**Application by East Anglia ONE North Ltd for East Anglia ONE North Offshore Wind Farm.  
EN010077 REF 20024721**

**Application by East Anglia TWO Ltd for East Anglia TWO Offshore Wind Farm  
EN010078 REF 20024704**

## **DEADLINE 2 RESPONSES**

Drawing file: published-documents / EN010077-001079-6.2.7.7 EA1N ES Figure 7.7 Offshore Cable Corridor and Landfall.pdf

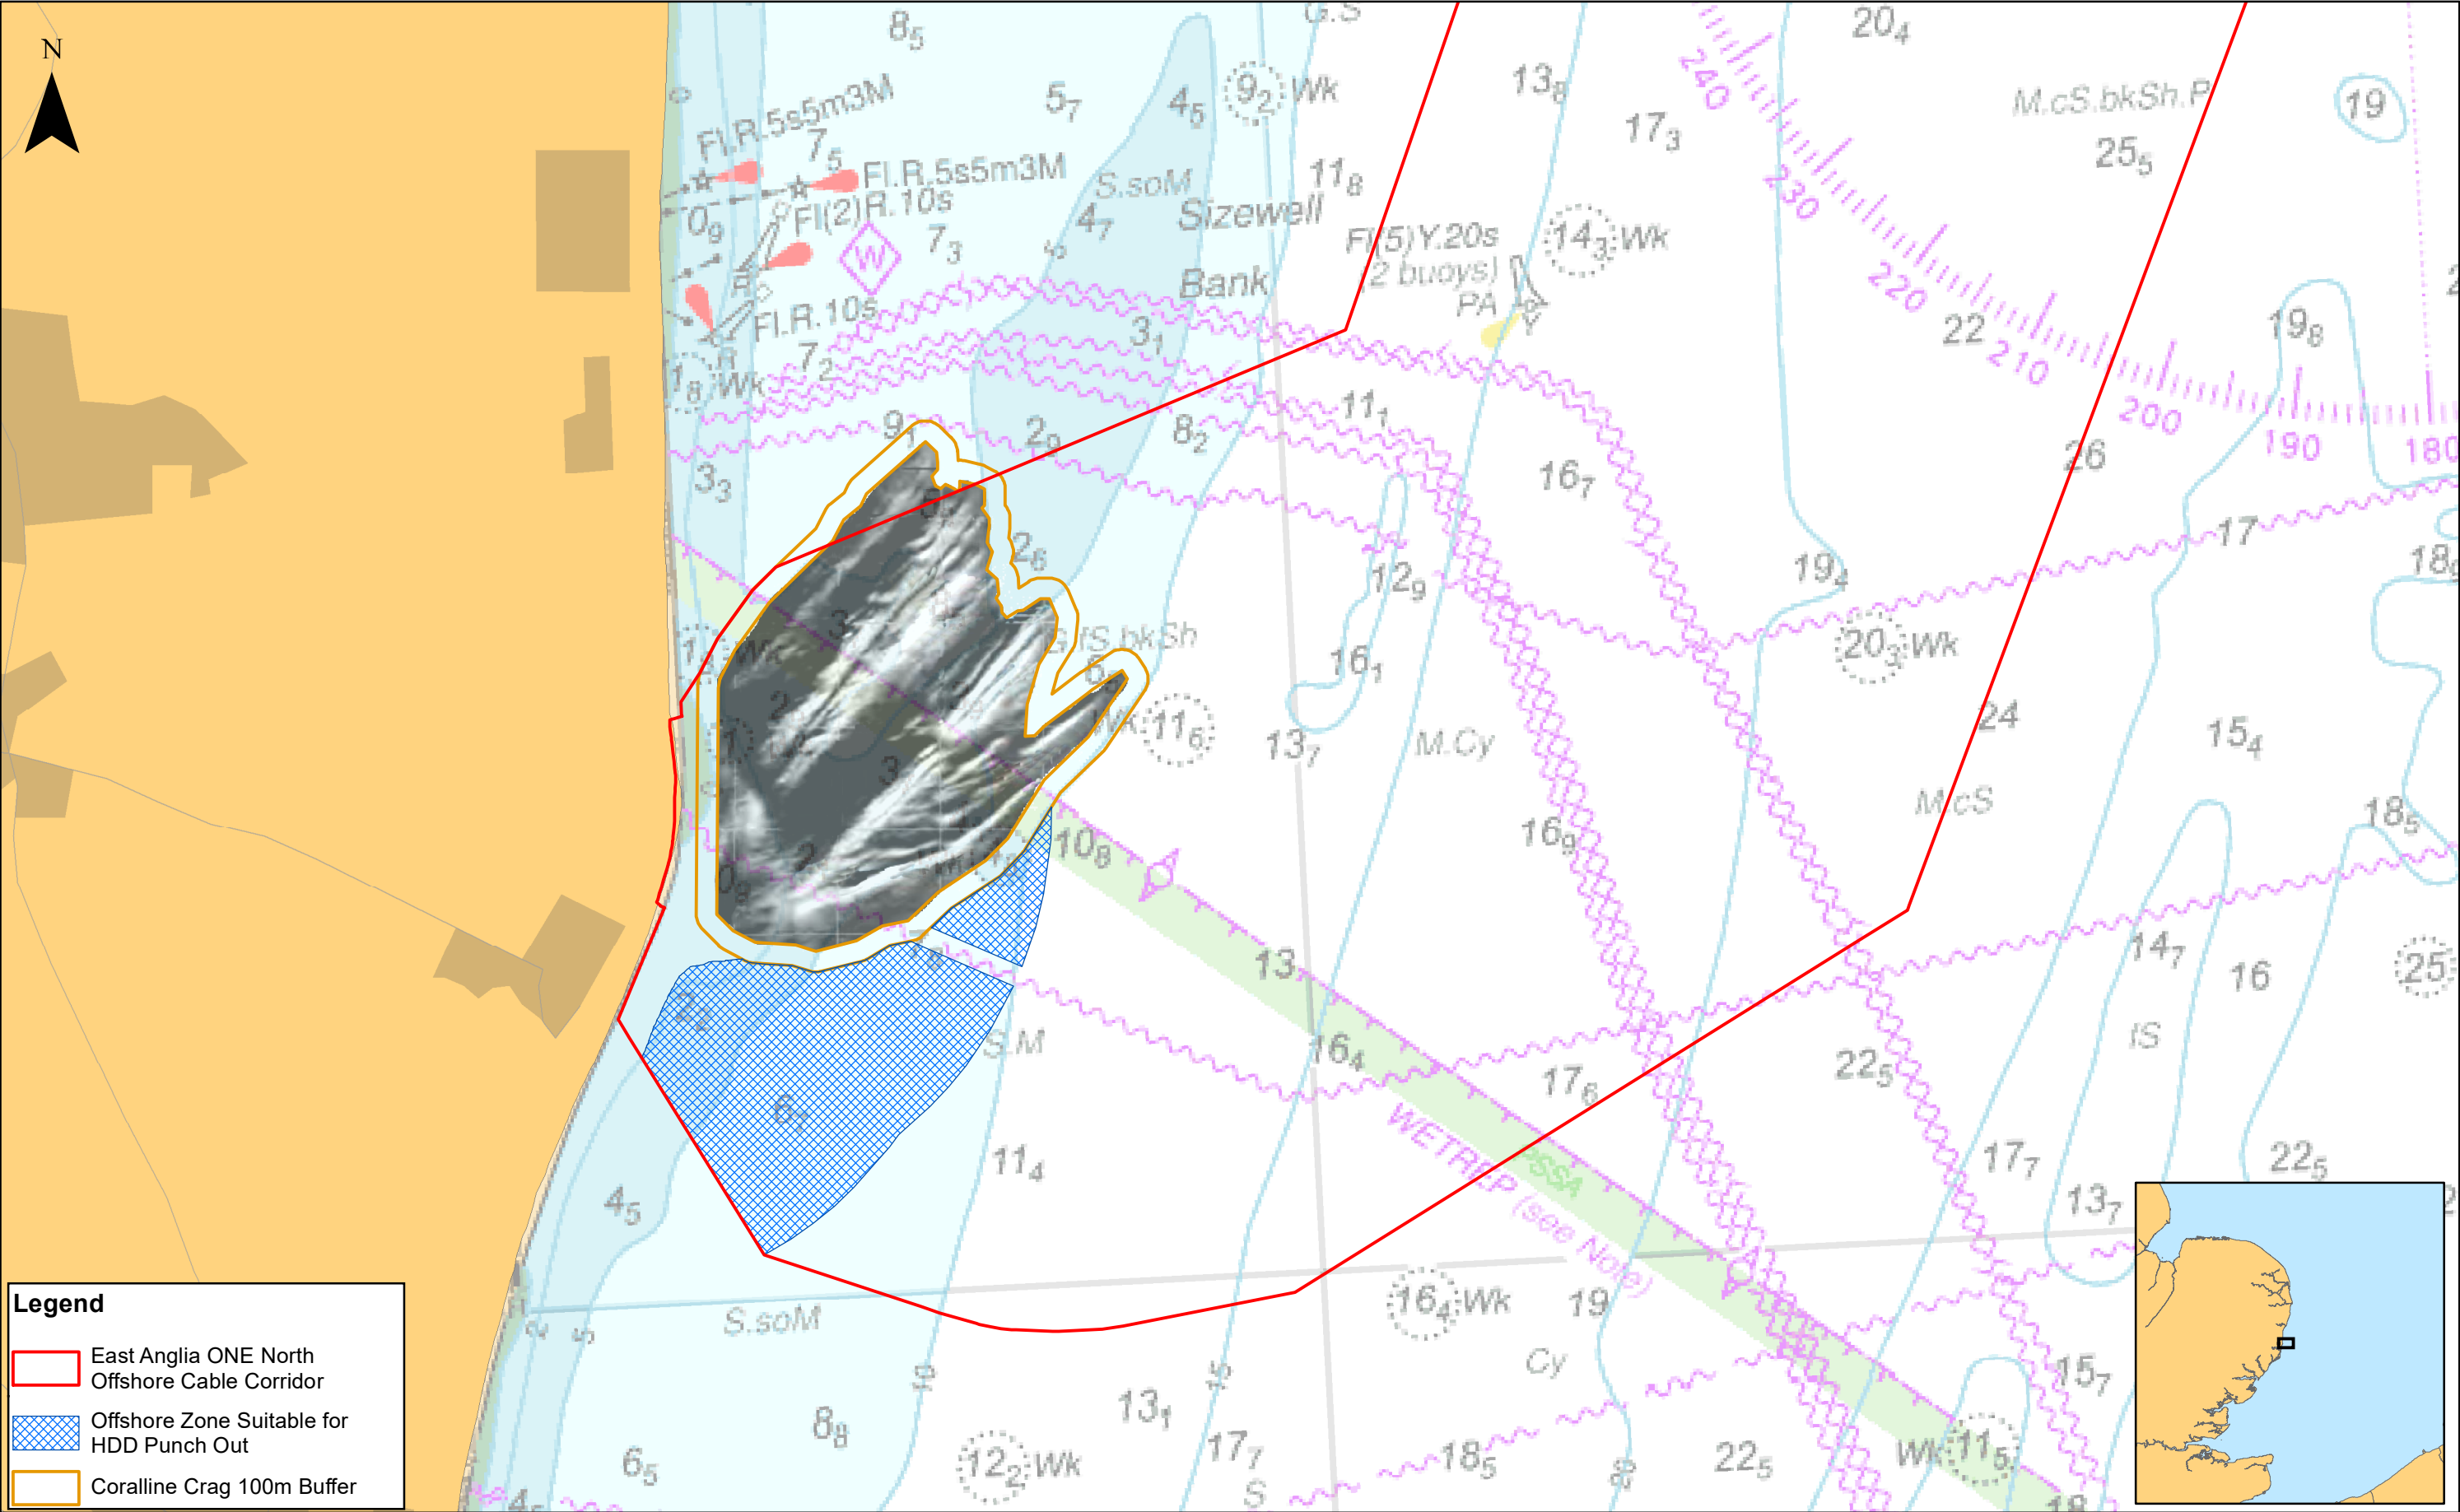
The mapped extent of the coralline crag may have changed since the maps used in Figure 7.7 Offshore Cable Corridor and Landfall (APP-109) of the ES.

Up to date geophysical surveys should be undertaken to confirm the current extent of the Coralline Crag formation. This should be a commitment in the OLCMS.
